RFI

RFI #: 200
 Date: 10/22/2012
 Job: EB-02 Keller Springs Floors
 Phone: 877-777-5115

Subject: B2 Part 4 unit Columns and patio dimensions

Drawing: 2.7A, 3.1C, 3.2C, 3.4C, S2.23, S2.33,
 S2.43

SHEET NUMBER
3.1C
BLDG PLAN 'C'

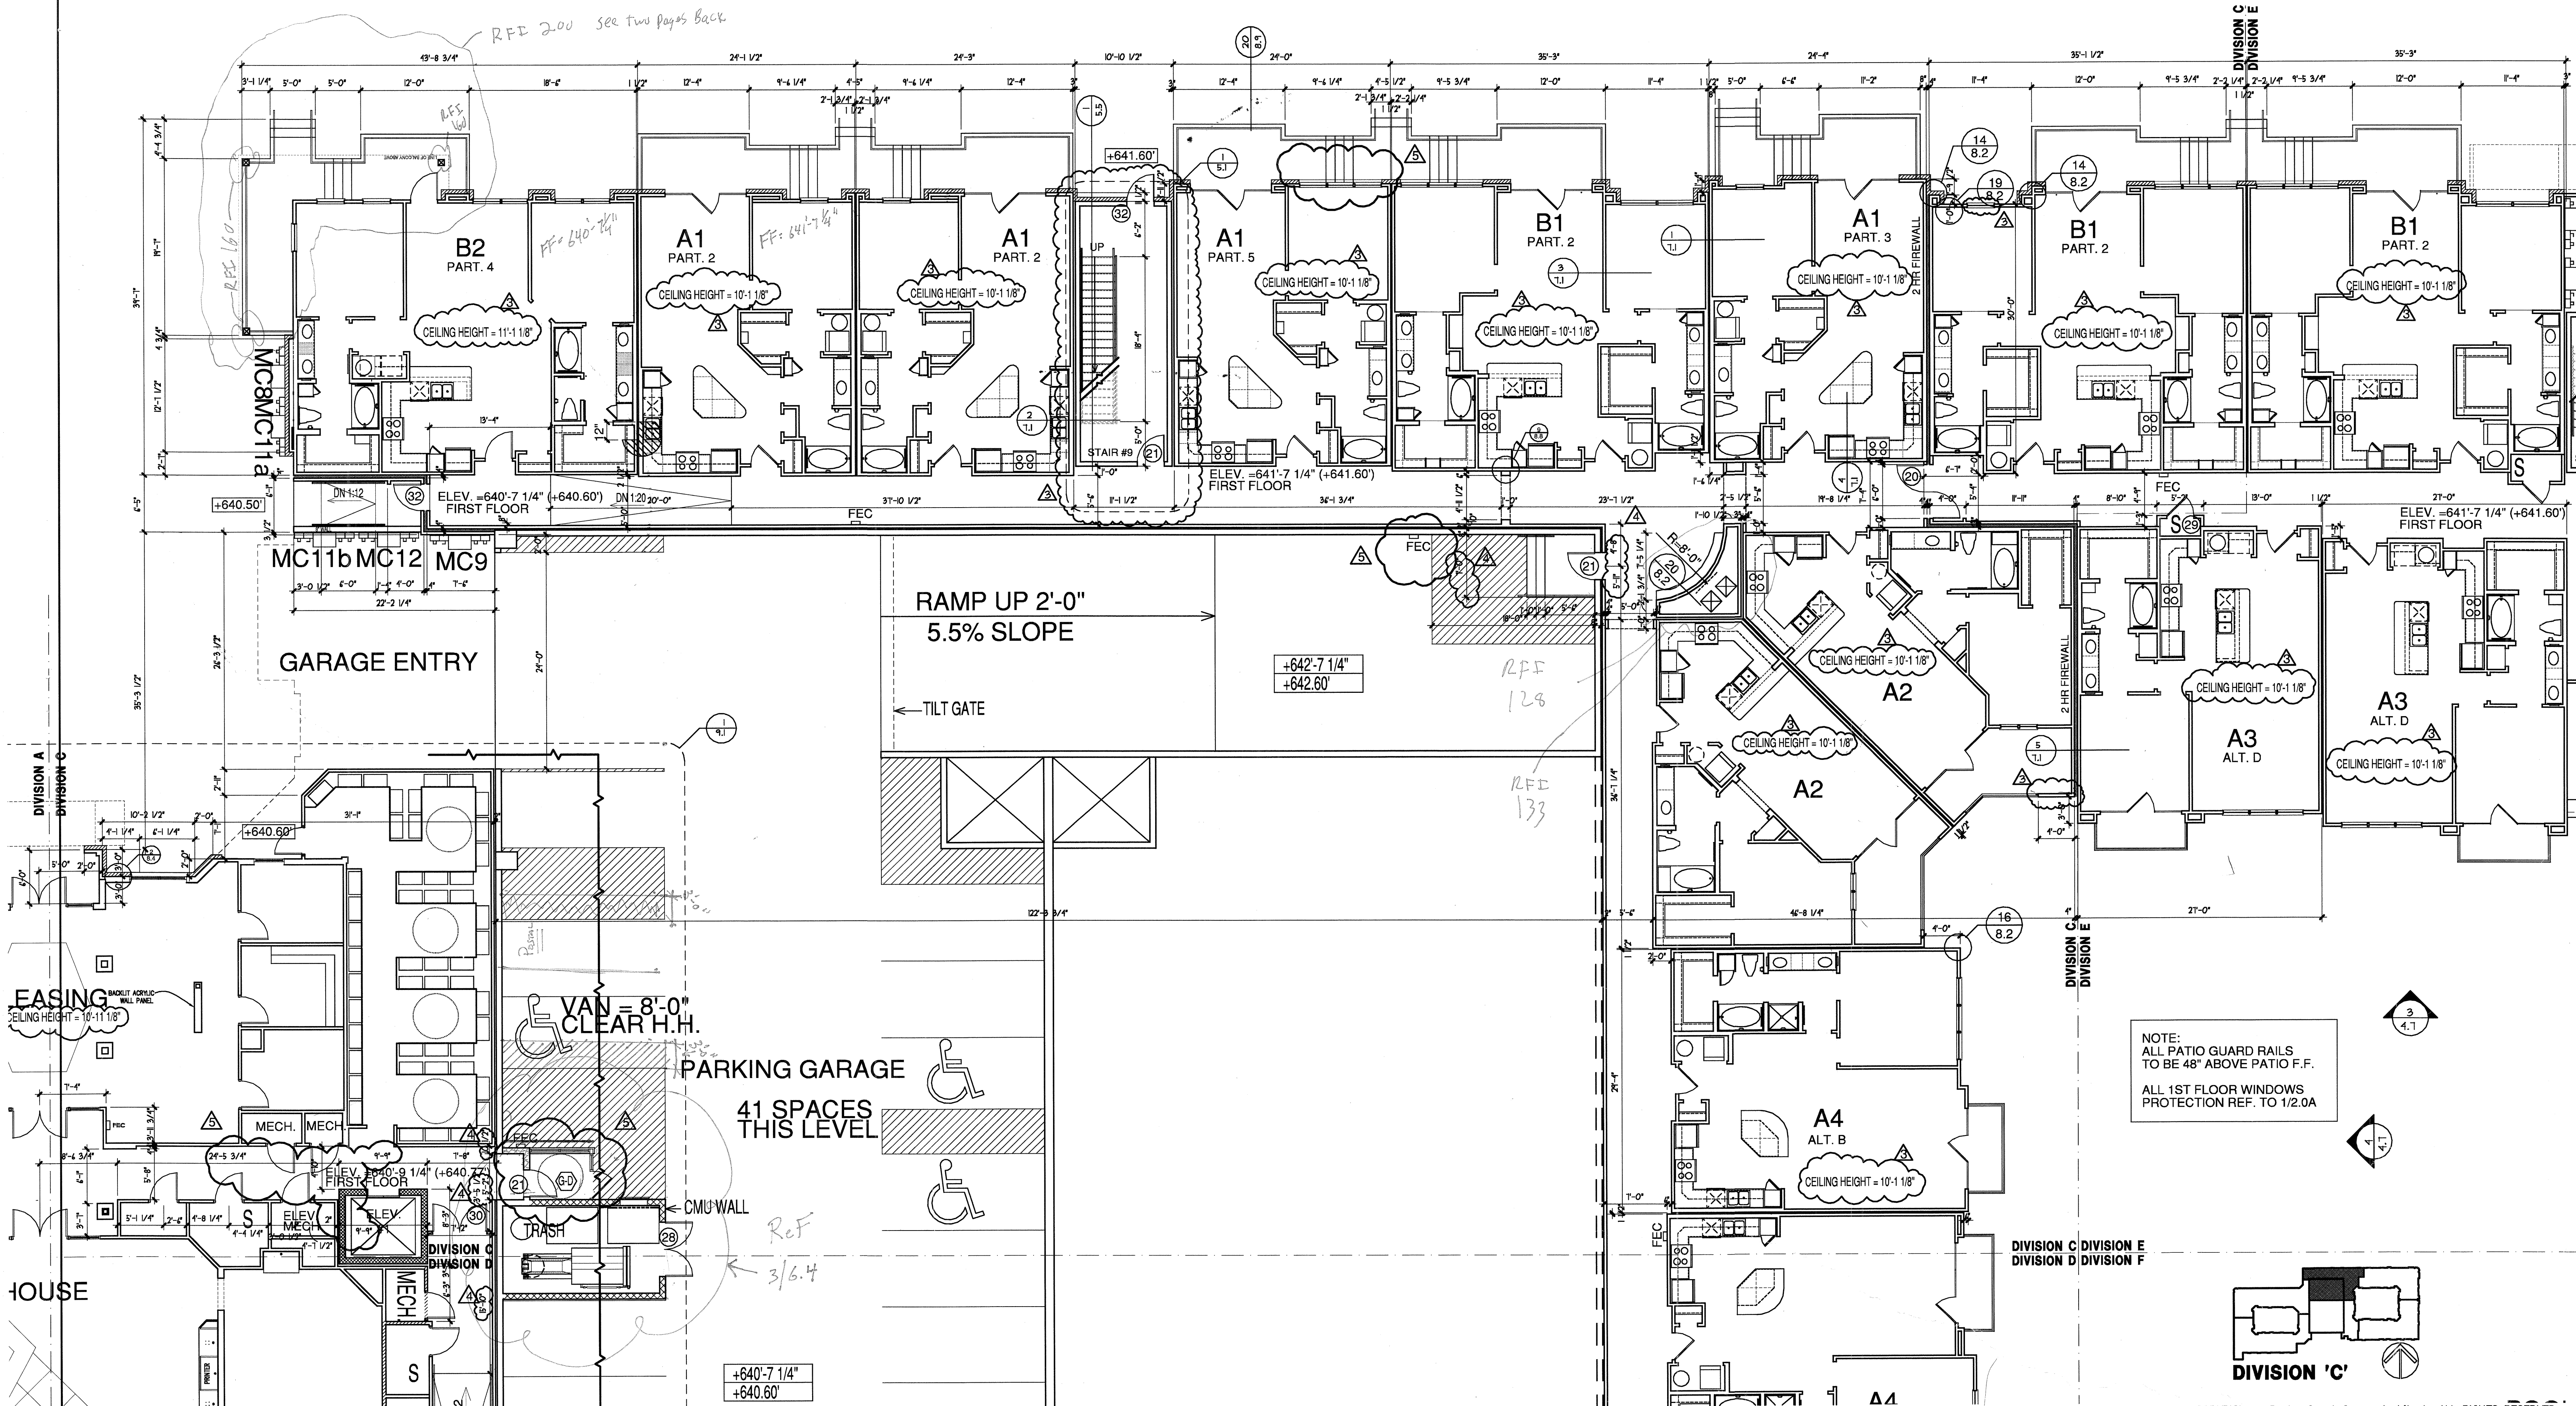
The attached RFI from Red River Framing is in reference to the B2 Part 4 unit columns and patio dimensions on 2/2.7A vs. the B2 Part 1 unit balconies above shown on 1/2.7A. The B2 Part 1 units show the supporting walls 'F' past the support columns from the B2 Part 4 units. Please review and advise.

PPO takes no exception to the cantilevered truss solution proposed below.

Please ask BGO to confirm that the solution is acceptable Architecturally.

BGO suggests cantilevering the trusses for these B2 units in question as shown in the next pages of this PDF only if the Trusses are signed and sealed by an engineer in the state of Texas.
